SWPPP COMPLIANCE INSPECTION REPORT

Date of Inspection	Tuesday, June 18, 2019
Project	Coors Village Offsite
Location	Western Trails and Coors Blvd

NPDES #	NMR10022T/NMR10022M
Permit Type	Construction General Permit
Inspection Type	14 day SWPPP Compliance Inspection

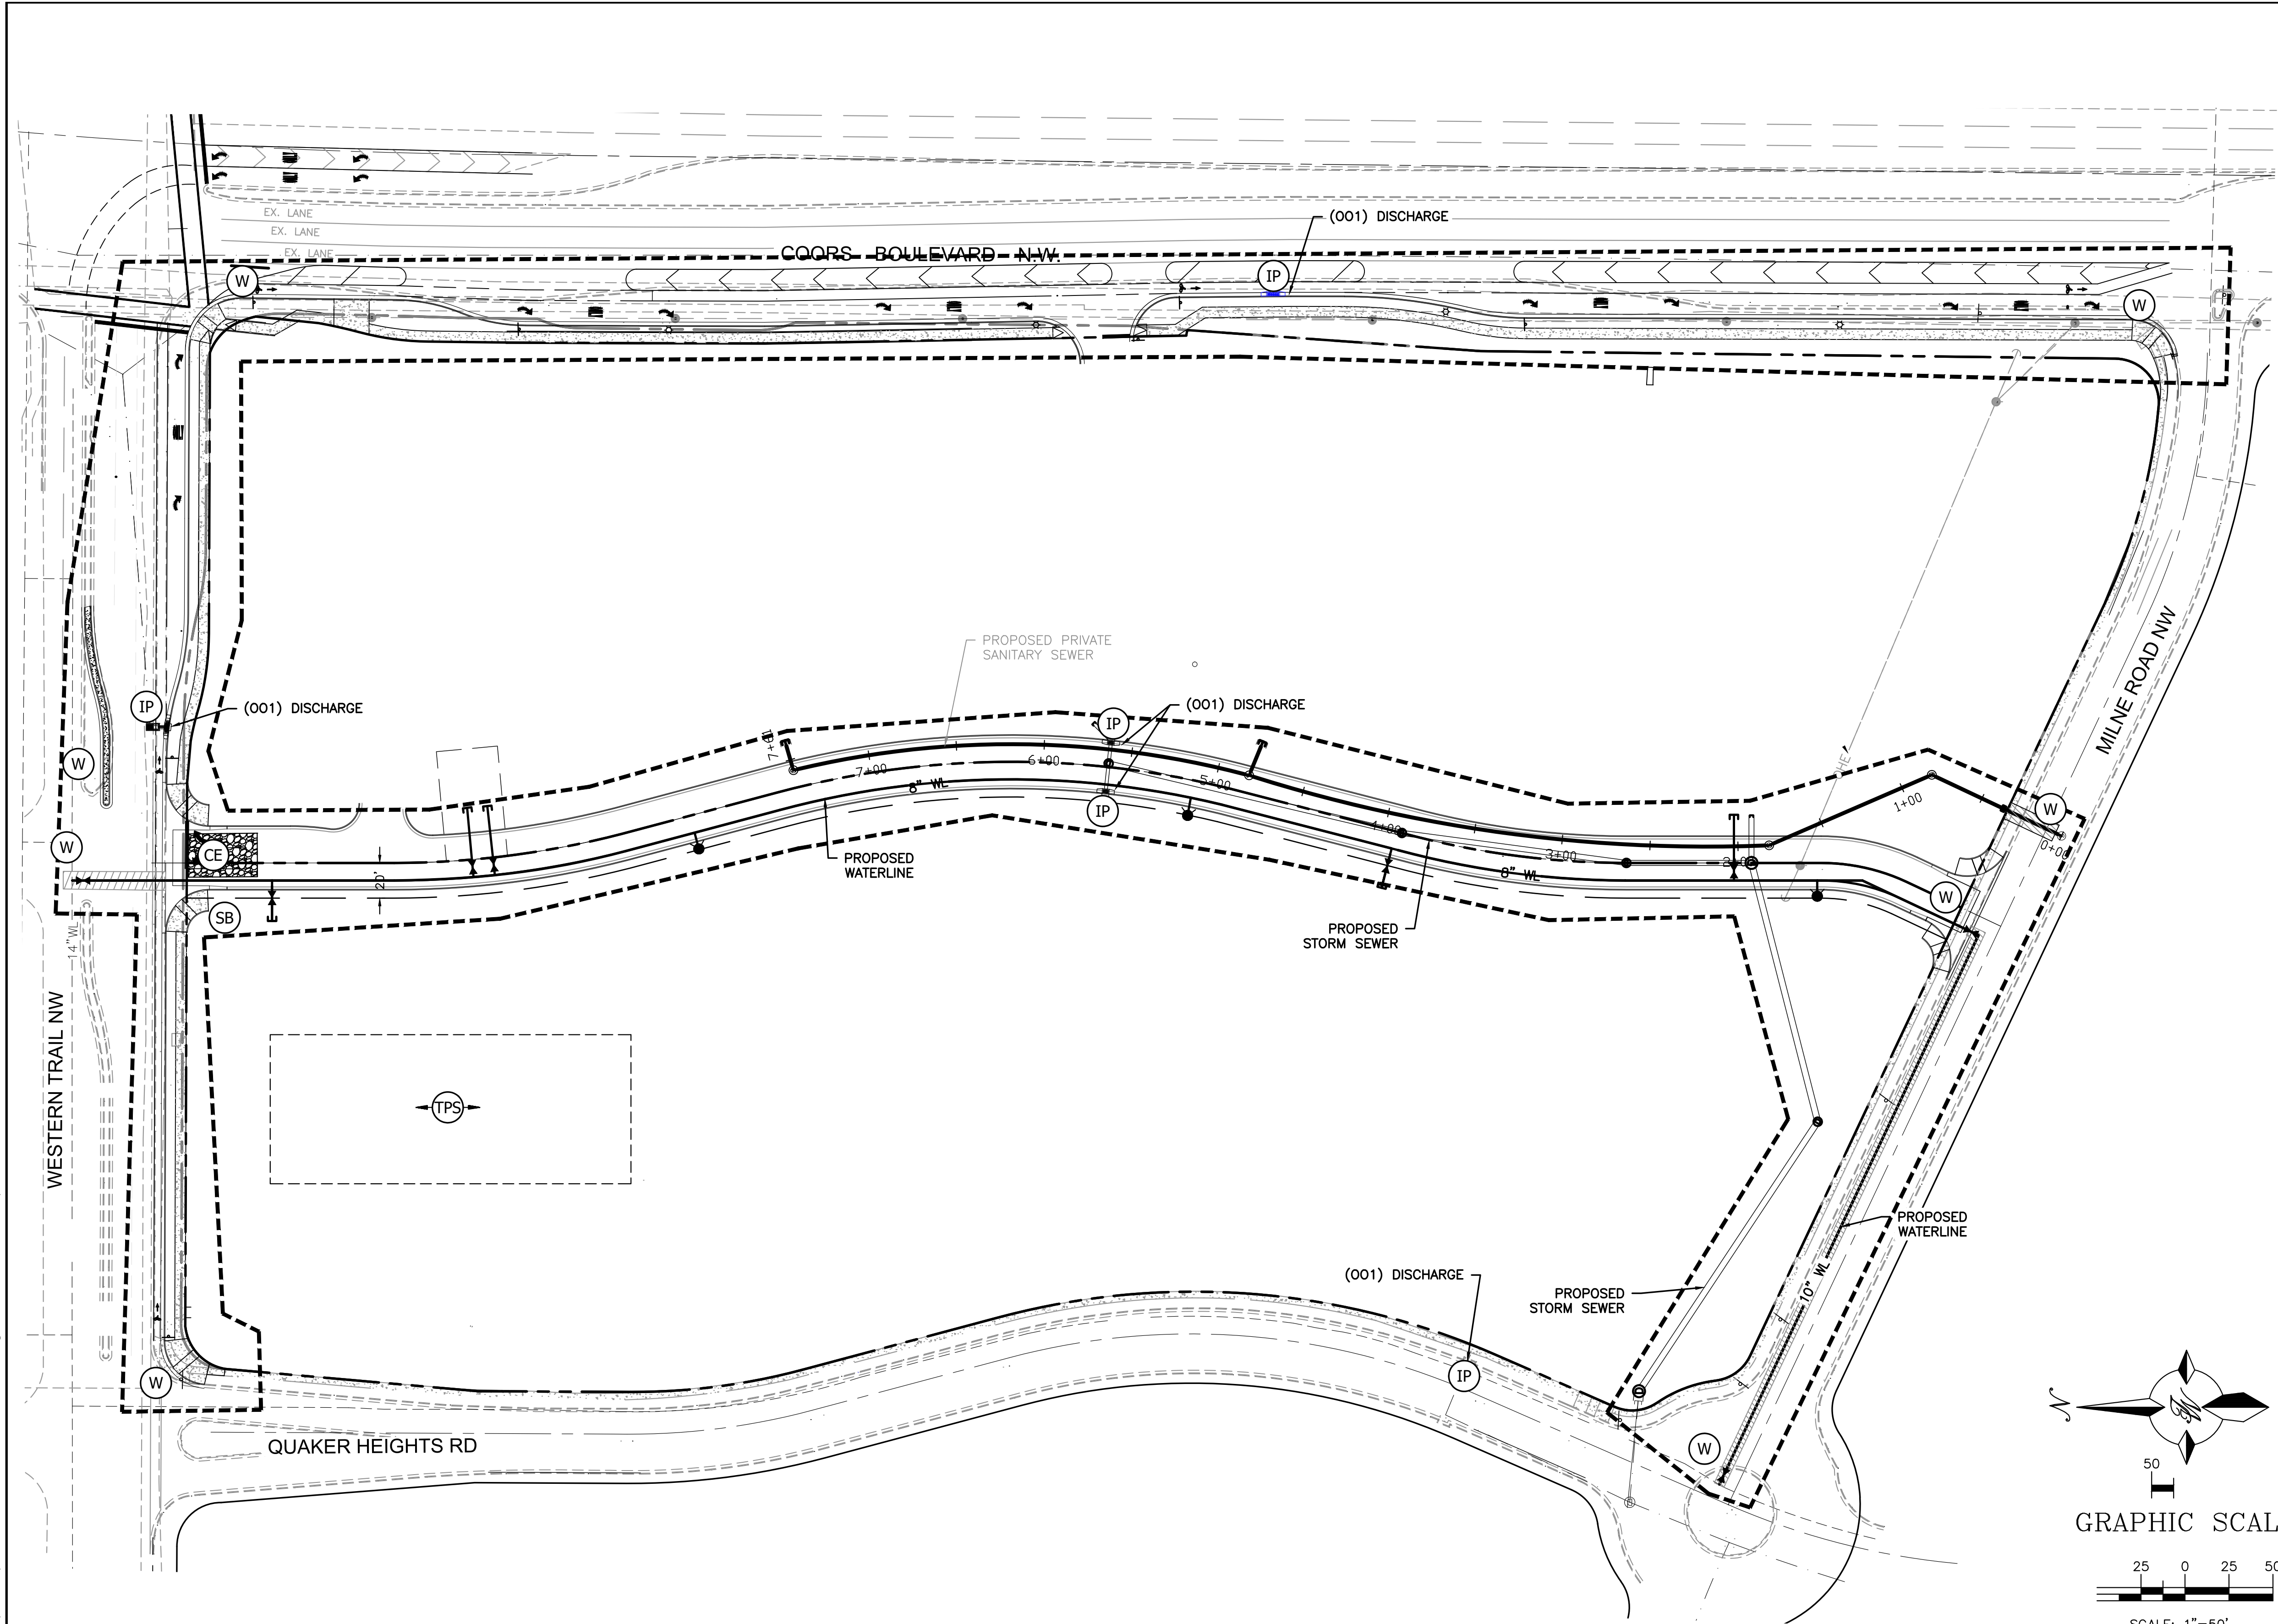
POLLUTION PREVENTION, SEDIMENT AND EROSION CONTROLS			
List Any BMP's Or Controls That Require Maintenance or Corrective Actions?			
Control	Location	Issue	Maintenance or Corrective Action?
Silt fence	West silt fencing	Fence down	Re set silt fence
Exit/entrance	Milne	Uncontrolled access	Add rock or close off

INSPECTION COMMENTS OR OTHER
Repair silt fence used for fugitive dust, close access or add rock for stabilized access at Milne
